SUBMISSION RE APPLICATION 07\_0103 APEX ENERGY  
EXPLORATION PROJECT

In my comments on the Application, page numbers mentioned are those in the Environmental Assessment Report by Olsen Consulting dated March 2009.

Borehole AI16

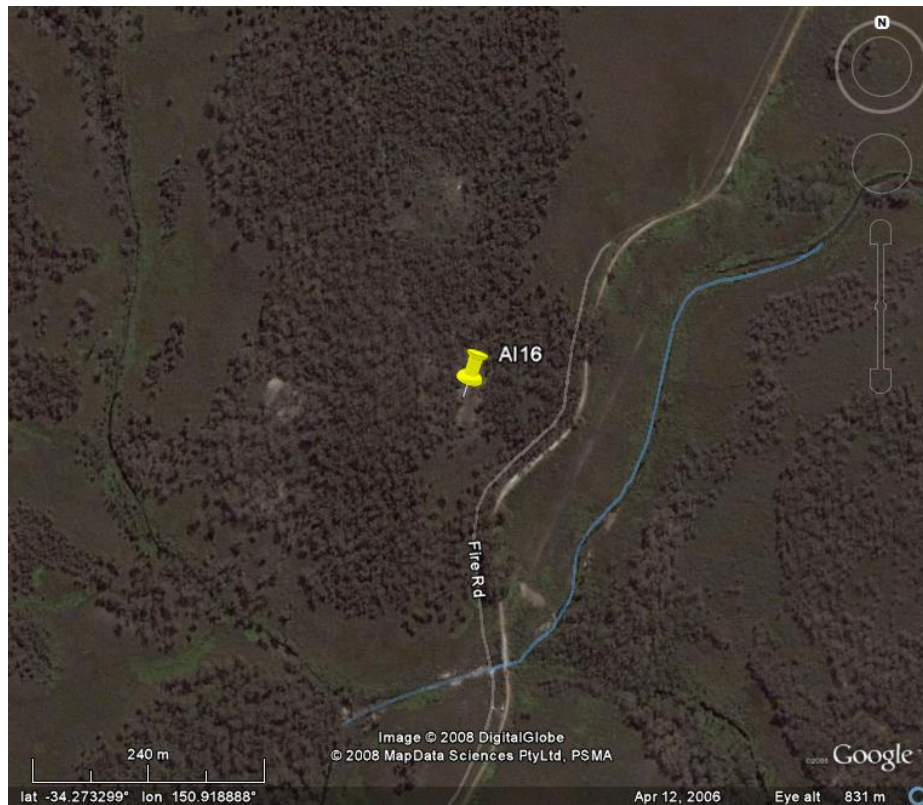
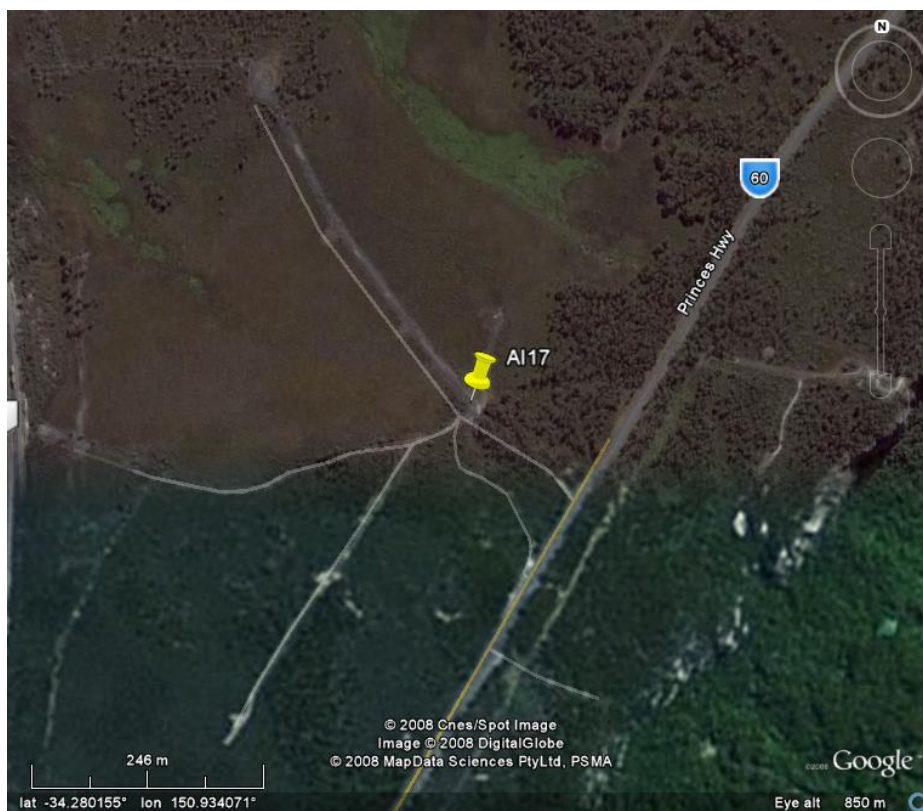
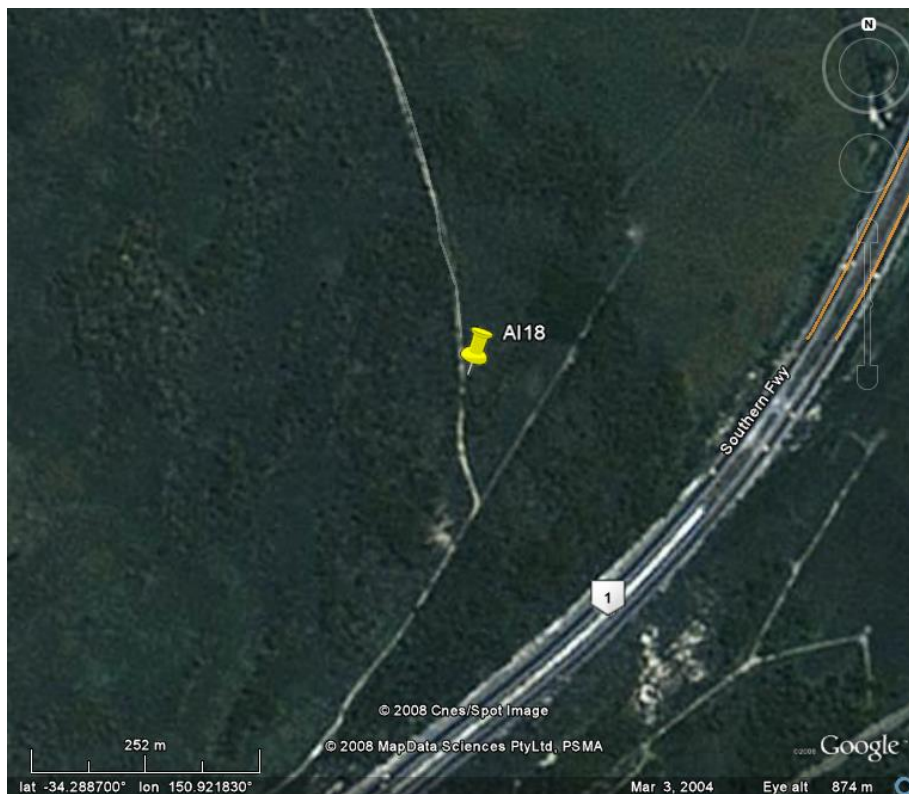
p 2. Although the drill sites are mainly near or on existing tracks, and the total area to be cleared is not large, this does not mean that environmental impacts are negligible. As the Google images on pp 20-26 show clearly, only A114, A116 and A118 are on wooded ridges. All other sites are beside upland swamps, and a 50-60m radius of disturbance as indicated on p31 would encroach into the swamps. This means that there would be a significant increase in the existing disturbance, and the additional impacts of compaction and channelled runoff across the surface. Also, while many of the sites lie beside existing fire trails, these trails are not heavy duty access roads. To give the drill rigs and other large vehicles access along them is likely to cause significant widening and disturbance, especially for the work-over rigs (p40). This project will NOT simply operate without any noticeable change in the local environment. Similarly, the comment that these corridors would be used for subsurface reticulation of any developed wells (p9) glosses over the impacts of the traffic needed to dig trenches, lay pipes etc. And as is shown by Figure 3.5 (p32) and the details of sumps etc on p 56, there will be drains, bunds and levelled areas constructed, not just a small area 'cleared'.
